Your ref:	Eyre Court	<b>Please reply to:</b>	Rayhan Ali
Our ref:	23/07025/FULL	Tel No:	07866033247
		Fee Queries:	0207 641 6500;
		Email:	planningreception@westminster.gov.uk;
Mr Gregory Mc Kinney Opsis Design 18, 71H Drayton Park, London N5 1DU		<b>Incomplete Applications</b> Town Planning & Building Control City of Westminster PO Box 732 Redhill, RH1 9FL	
		16 October 2023

**Address: Flat 20, Eyre Court, 3-21 Finchley Road, London, NW8 9TT,**

**Proposal: Installation of replacement windows including inseration of three Extractor fan at North Elevation.**

DWG.#:
PL-PR-01

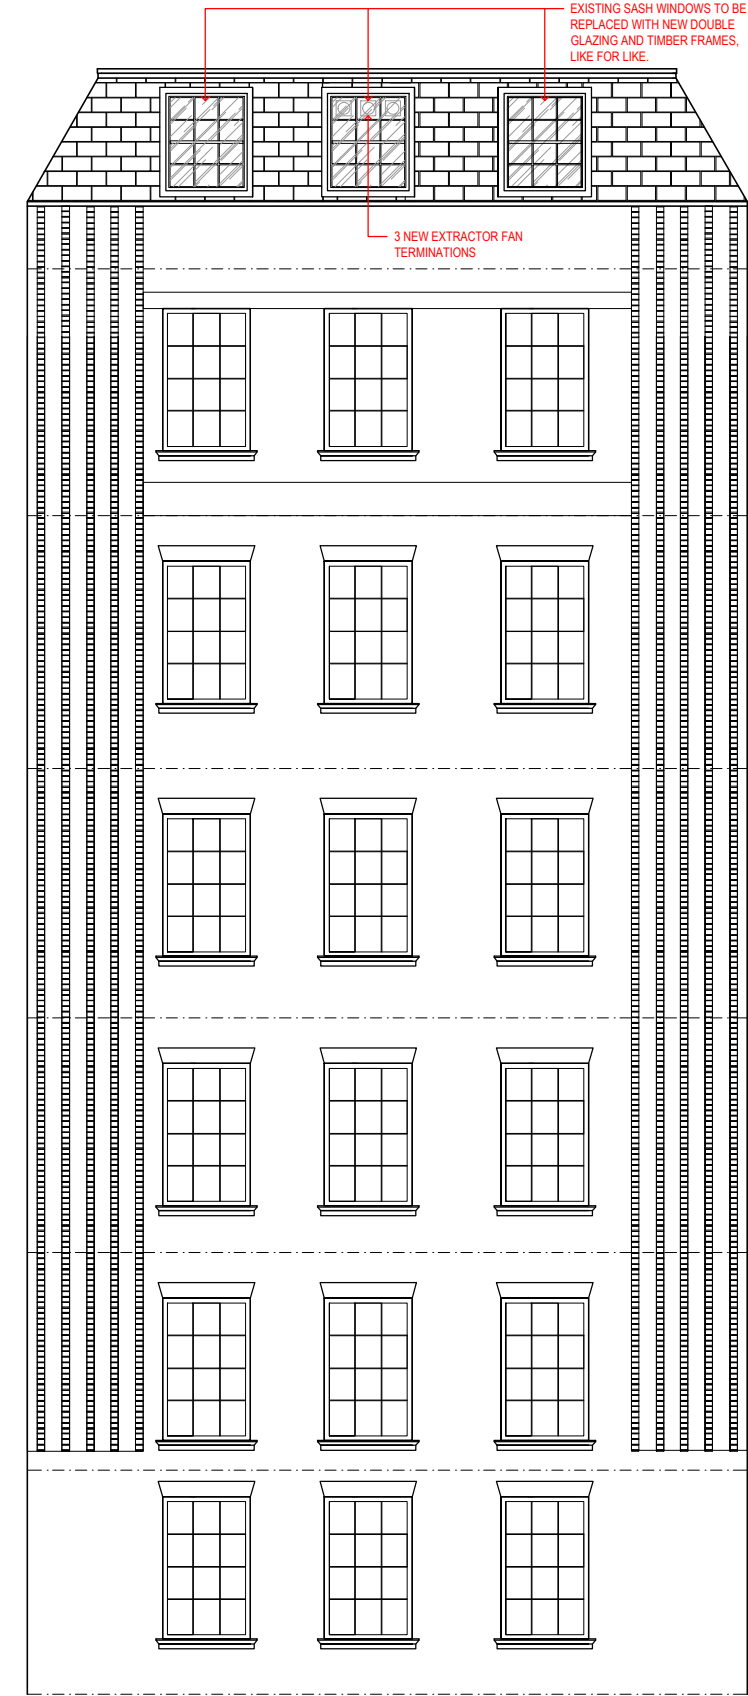
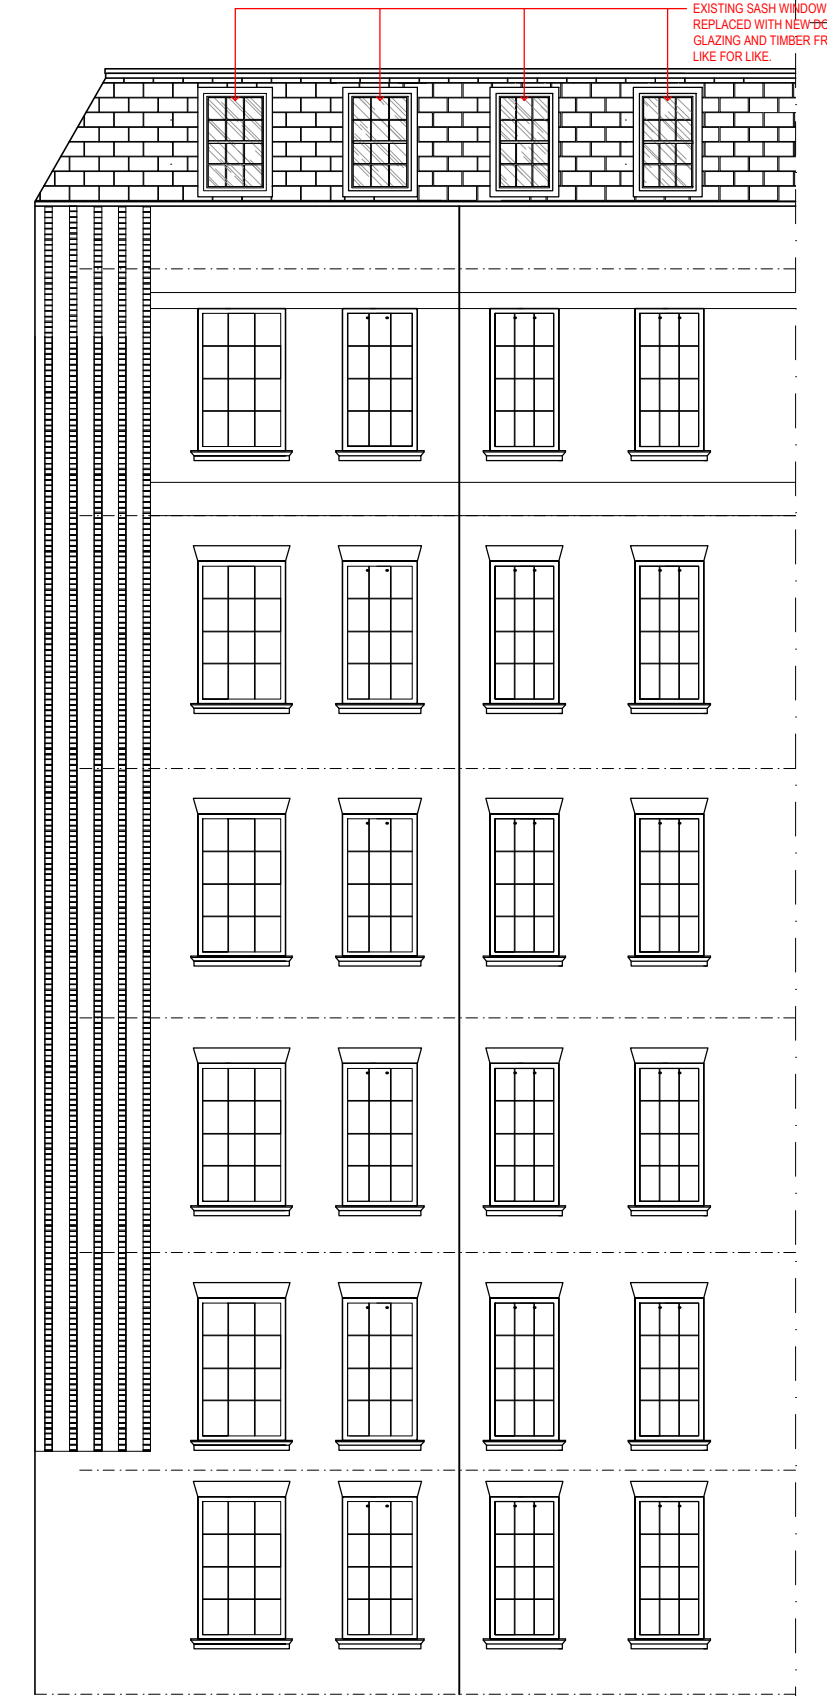
- 3 Please provide Proposed floor plan (to correspond with the submitted Existing floor plan)
  - 4 Your drawings show you are proposing for three extractor fans, if they are mechanically operated then please provide a noise report.
- 0 \*Please collate all requested information in a single submission and send to [planningreception@westminster.gov.uk](mailto:planningreception@westminster.gov.uk). Sending your documents individually will not speed up the process. Please do not upload to the planning portal as this causes duplication and may delay the processing of your application. Thank you.\*
